City of Sydney

23 March 2012

**Preferred Project Report for project application – Commercial Building C3,
Barangaroo, (MP11_0044)**

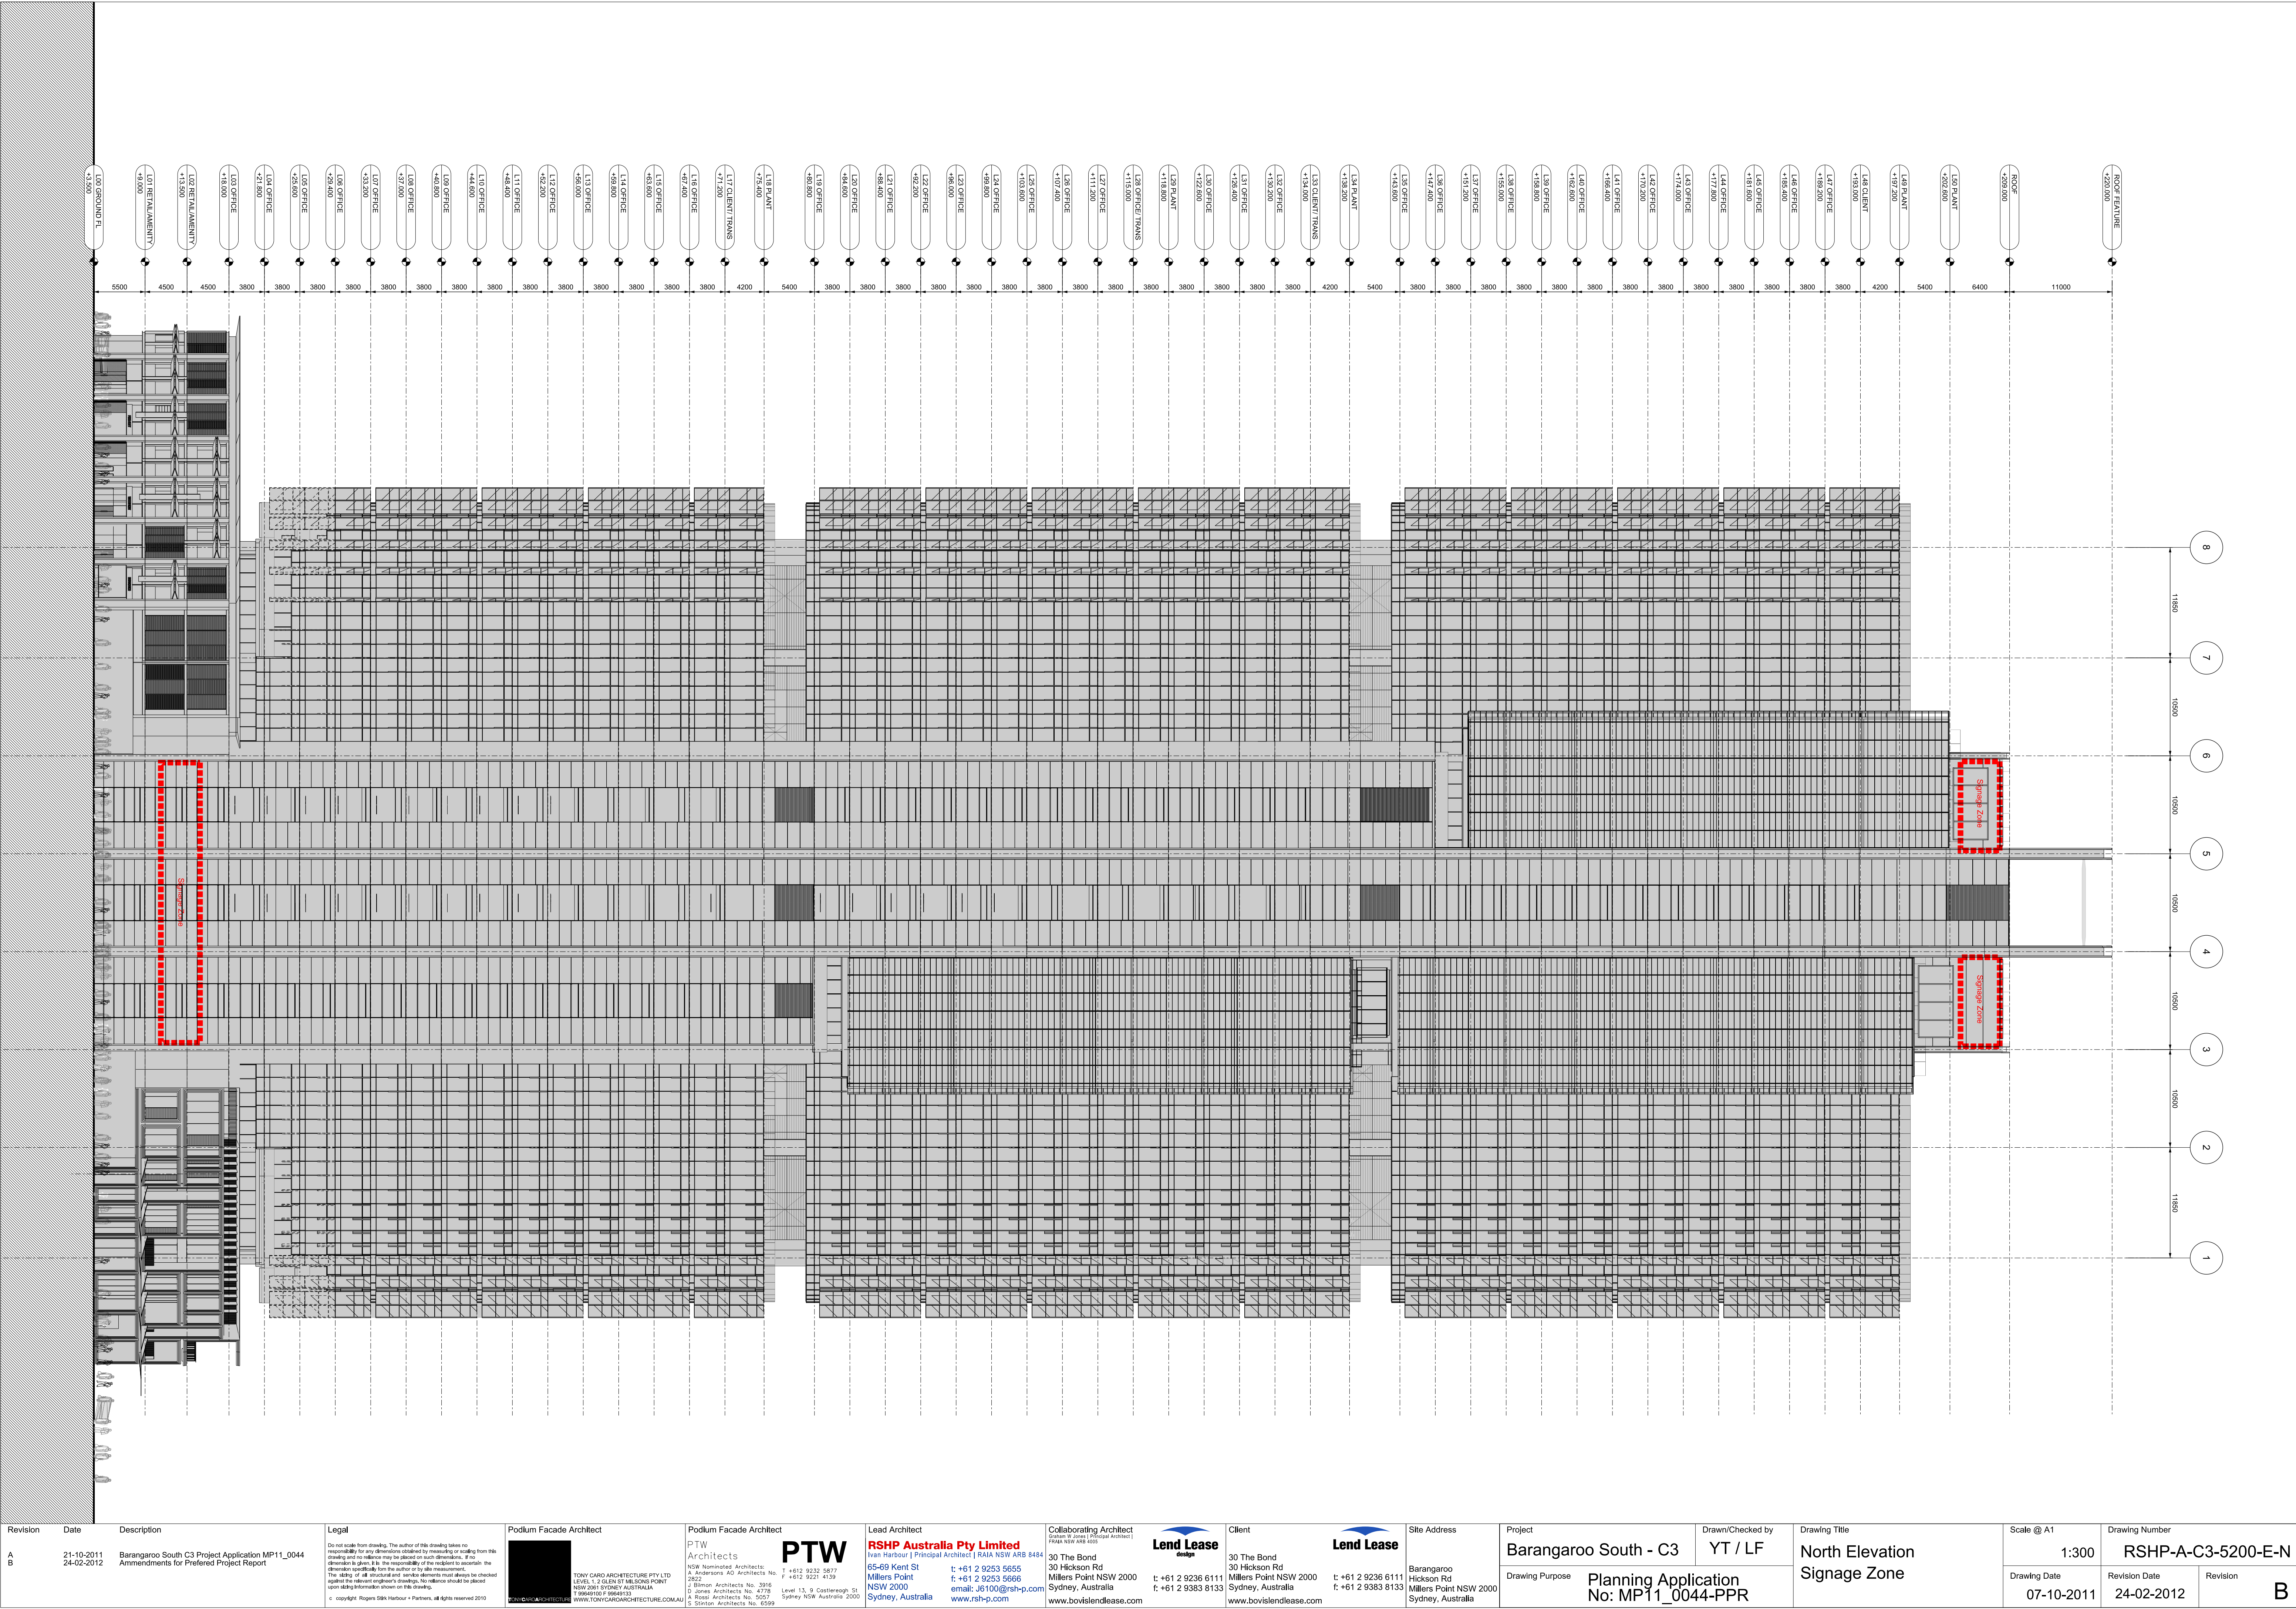
The Council is in the main satisfied by the responses provided in the PPR given the Concept Plan approvals have been granted and which ignore the Council's previous concerns. The Council's main concerns relate to the height of the podium, and stepping the building back above RL 120. The Council is of the view that the podium should have a minimum height of 24 metres. In addition, the City disagrees with the photomontage methodology. The City has made photomontages and these will be emailed to you separately.
